Our Ref: LU/354/17/HH
Your Ref:

Town & Country Planning Act 1990 (as amended)
Town & country Planning (Development Management Procedure) (England) Order 2015
Application for Planning Permission for Works or Extension to a Dwelling

Development Rear flat roof dormer & 3 No. pitched roof dormers at front.

Location 3 Barn Close Littlehampton

Proposed Front/SW Elevation

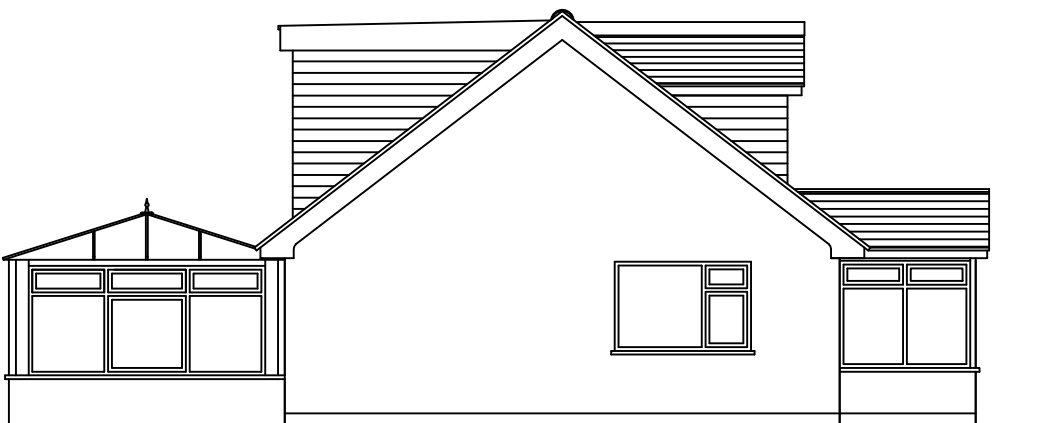
Please confirm if you wish the proposed front porch to be included in the description for the application.

Existing Ground Floor Plan

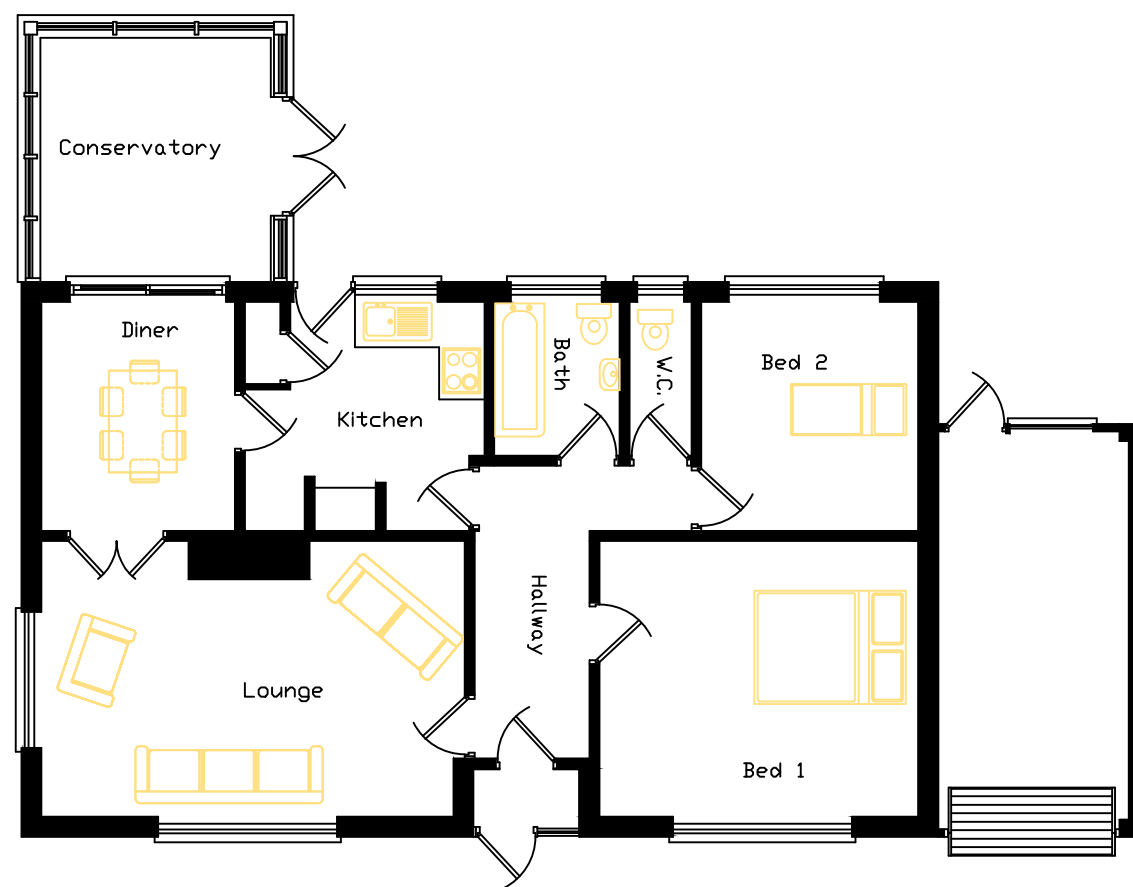
The existing ground floor plan and south east elevation do not accord. Please amend accordingly.
